PLANNING BOARD REPORT PORTLAND, MAINE

Mixed-Use Development 23 Ocean Avenue Level III Site Plan and Subdivision Review 23 Ocean Avenue Association, LLC

Submitted to: Portland Planning Board	Prepared by: Nell Donaldson, Planner
Date: October 21, 2016	CBL: 129-G-1
Public Hearing Date: October 25, 2016	Project #: 2016-120

**SITE PLAN**

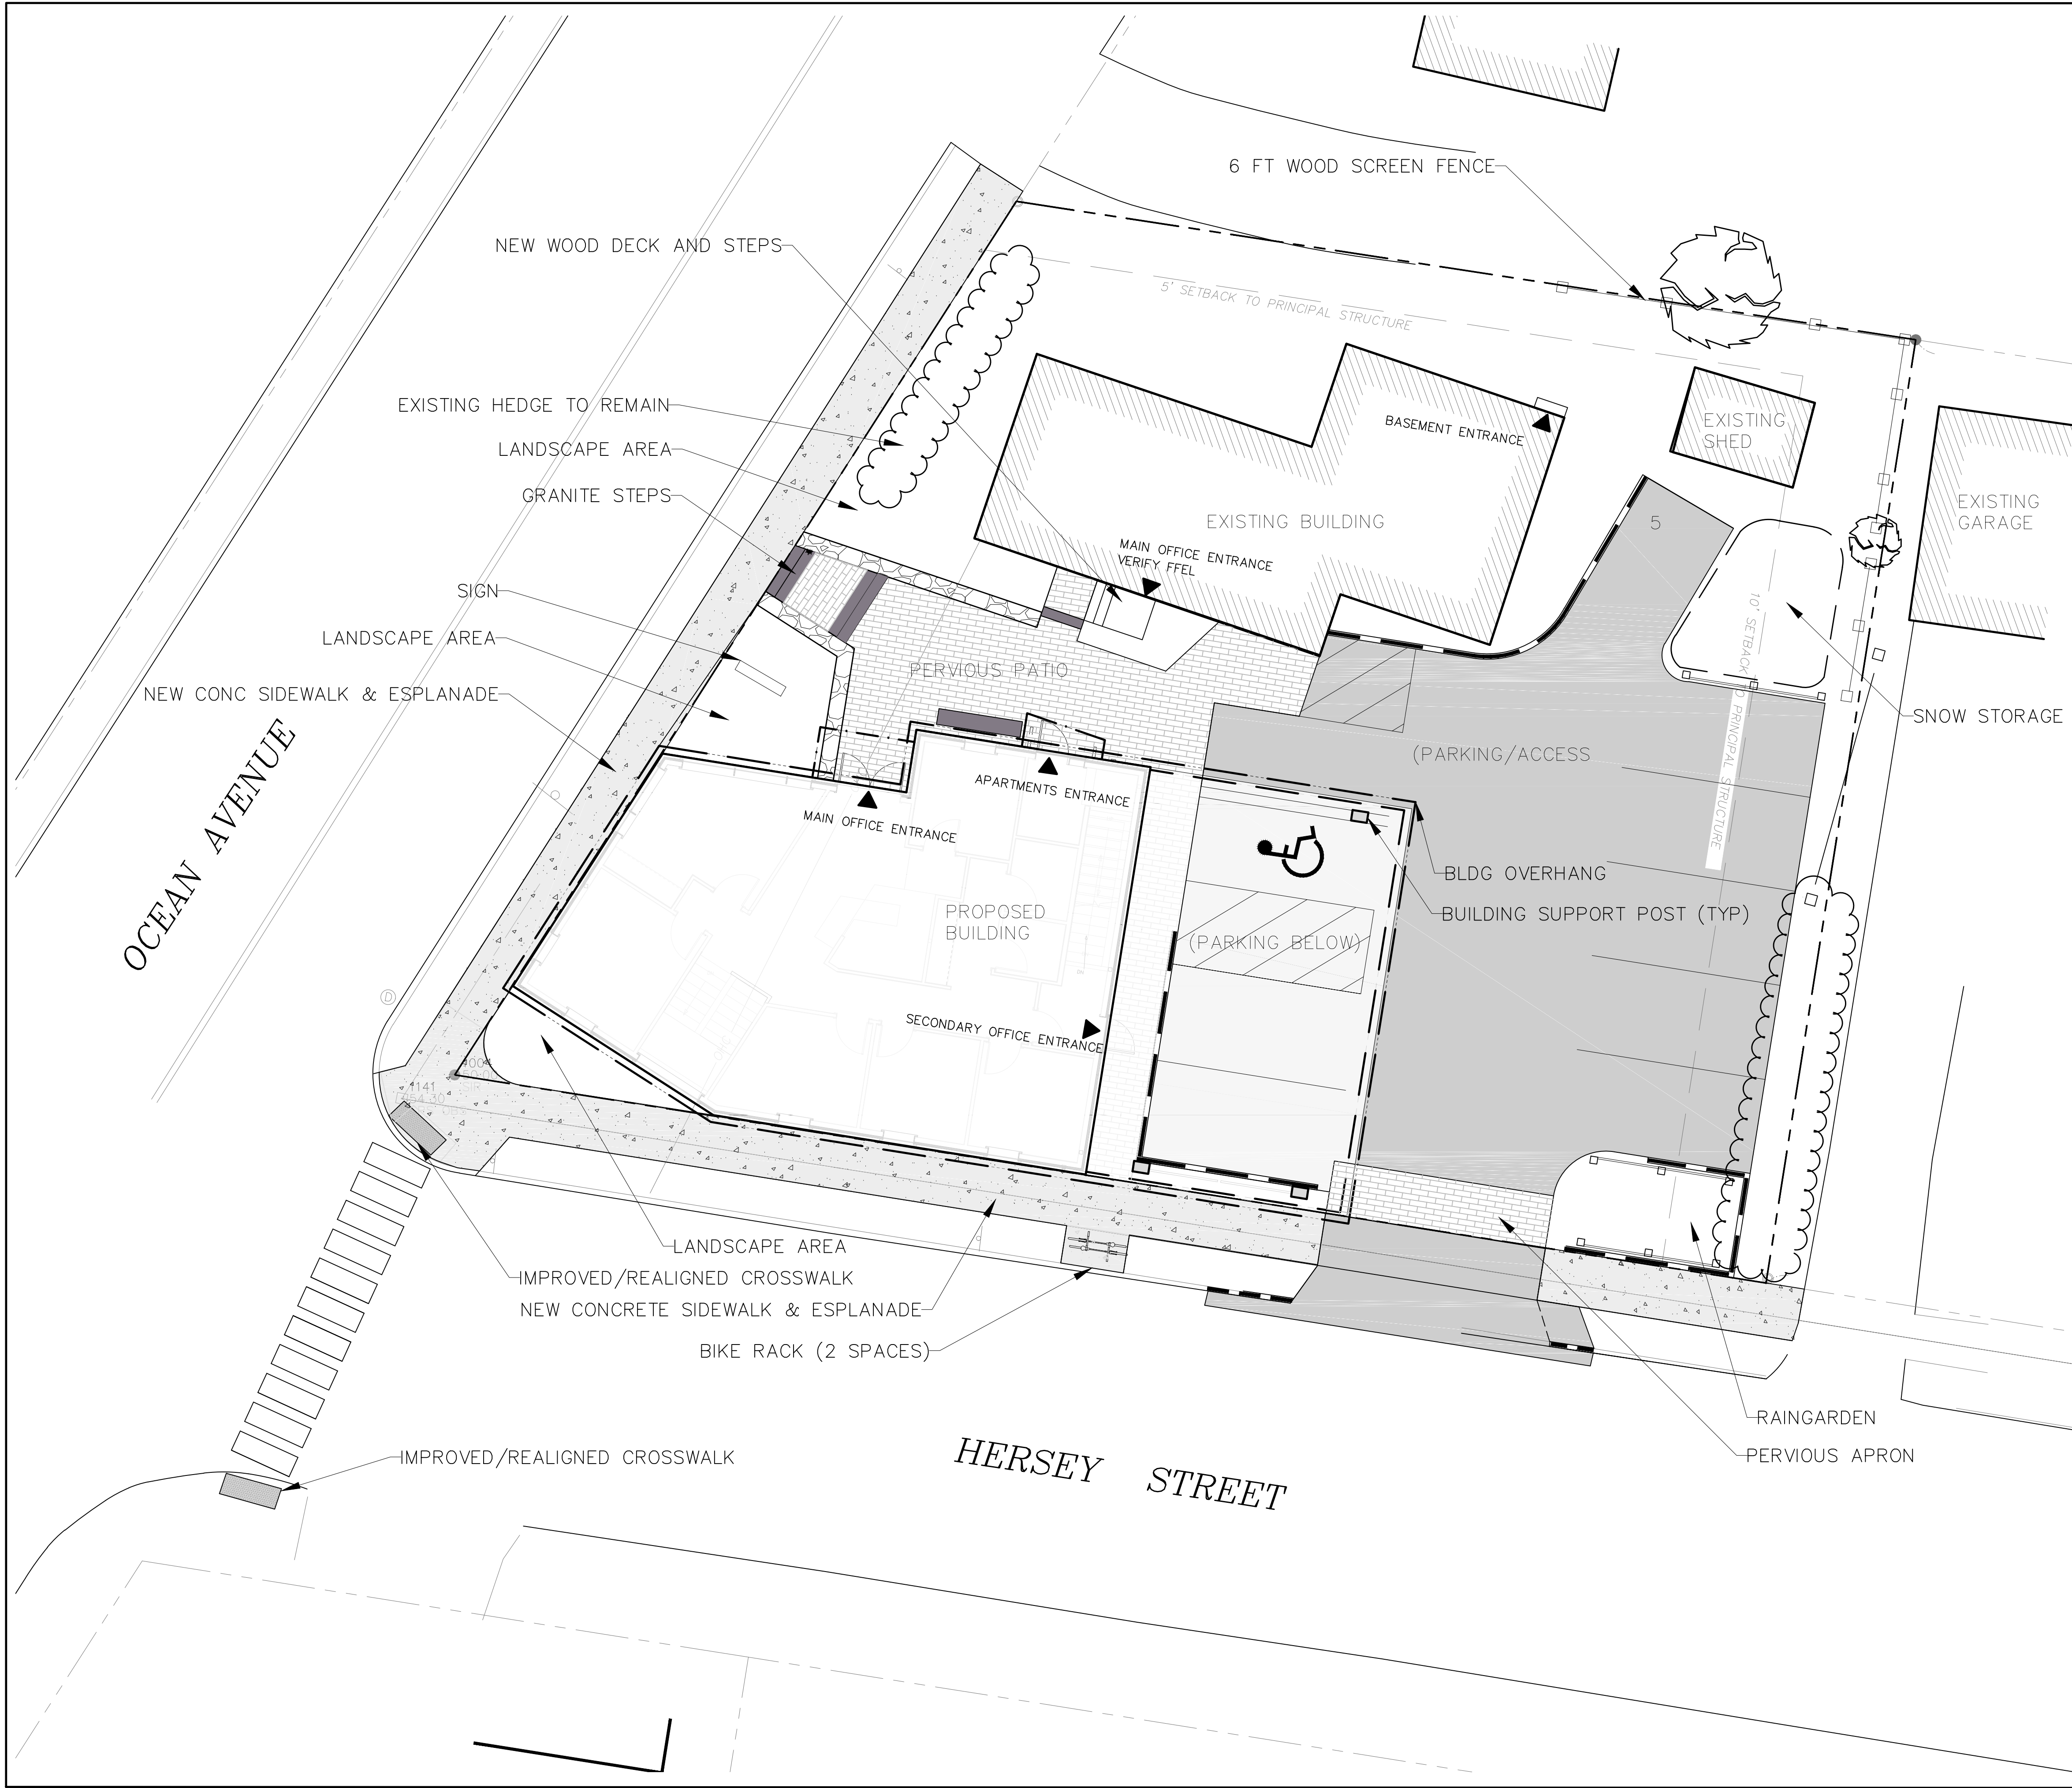
At the request of Jeff Tarling, the city's arborist, the applicant has revised the landscape plans to show two zelkovas on the Ocean Avenue frontage, three Armstrong maples in the esplanade on Hersey Street, and a cherry tree at the corner of Ocean Avenue and Hersey Street. Collectively, these trees meet the city's street tree requirement of one per unit. It should be noted that staff has recommended a condition of approval to address a potential conflict between the cherry tree and a stormwater treatment unit proposed for the Ocean Avenue/Hersey Street corner.

- 6. The applicant shall provide revised plans to address the conflict between the proposed cherry tree and stormwater treatment unit at the corner of Ocean Avenue and Hersey Street for review and approval by the City Arborist and the Planning Authority.

B	REVISED PER CITY COMMENT	9-7-16
A	SITE PLAN PERMITTING	6-6-16
No.	Revision/Issue	Date
Design by:	JIM	Checked by: SJB
Drawn by:	JIM	Approved by: SJB
Project:	161.06035	
Sheet No:	C1

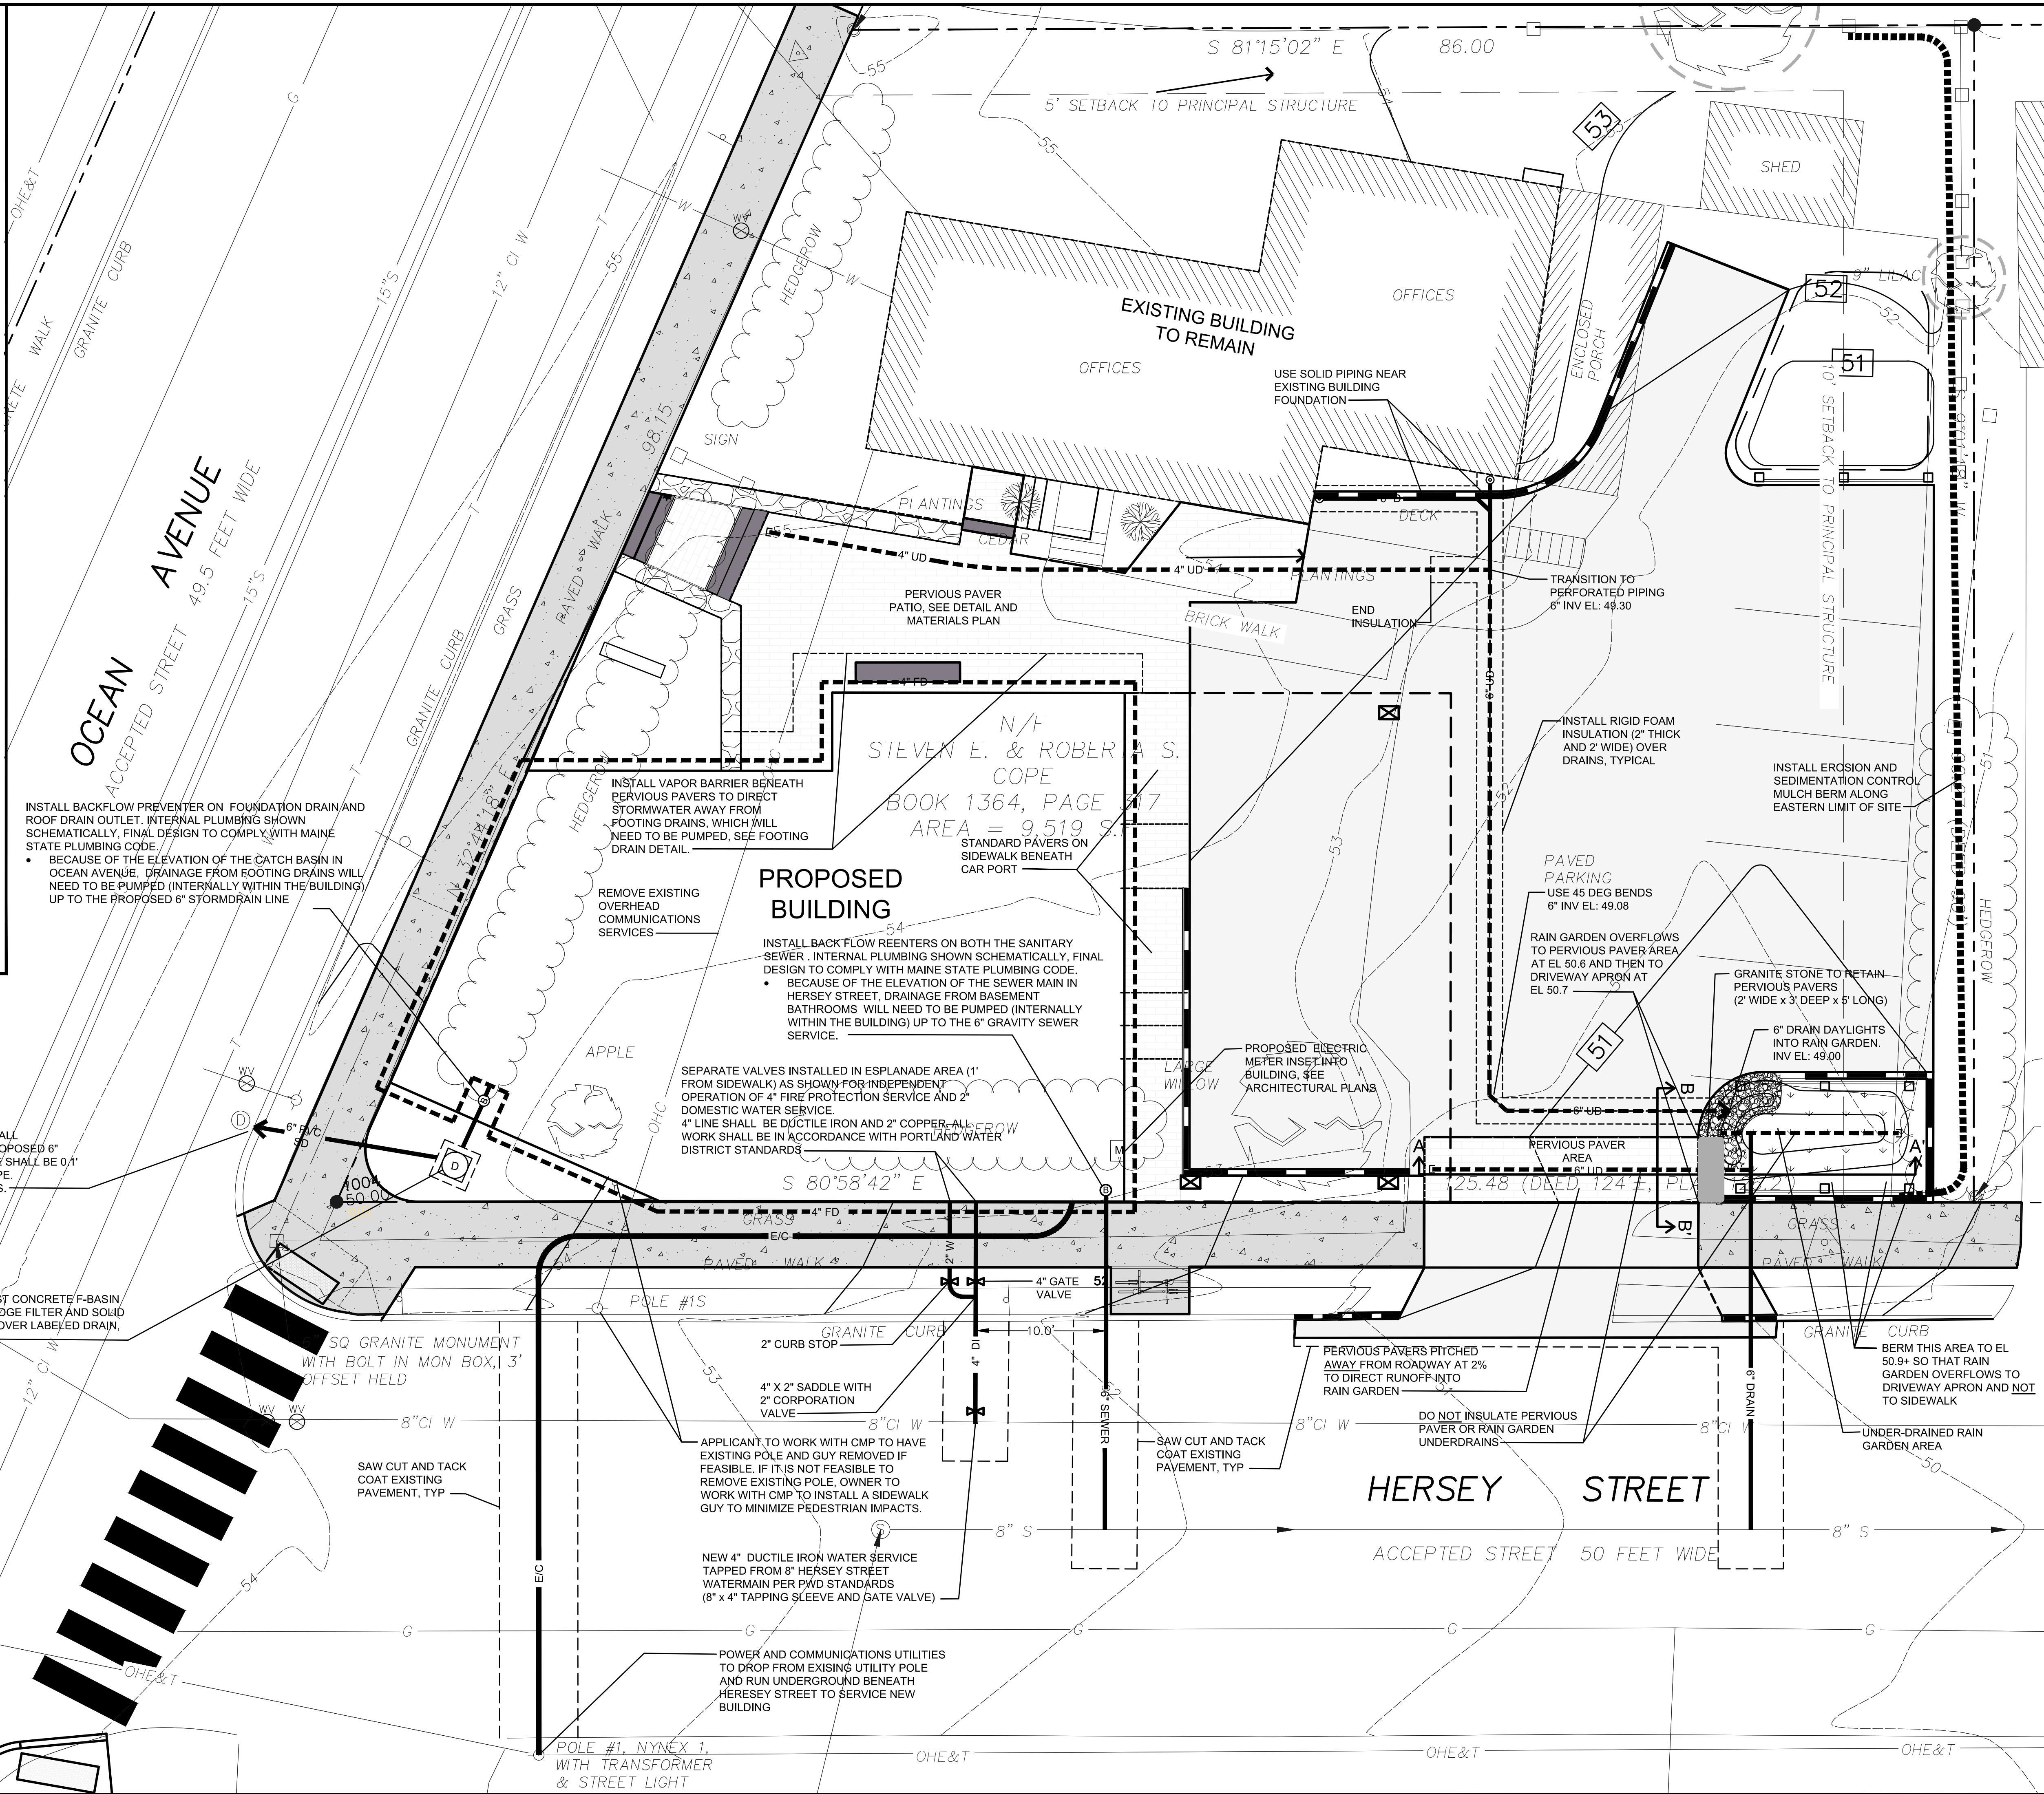
The project is required to include stormwater management features to control the rate or quantity of stormwater runoff from the site. The Applicant will be discharging a portion

of the site's stormwater to the combined sewer in Ocean Avenue. The site does not discharge to this location in the existing condition; however, the Applicant has discussed this condition with Public Works, and the connection will be allowed. Stormwater from the site will be collected as part of a future City sewer separation project. As a result of this connection, the stormwater discharge to Hersey Street will be reduced, providing an improvement over the existing condition on Hersey Street.
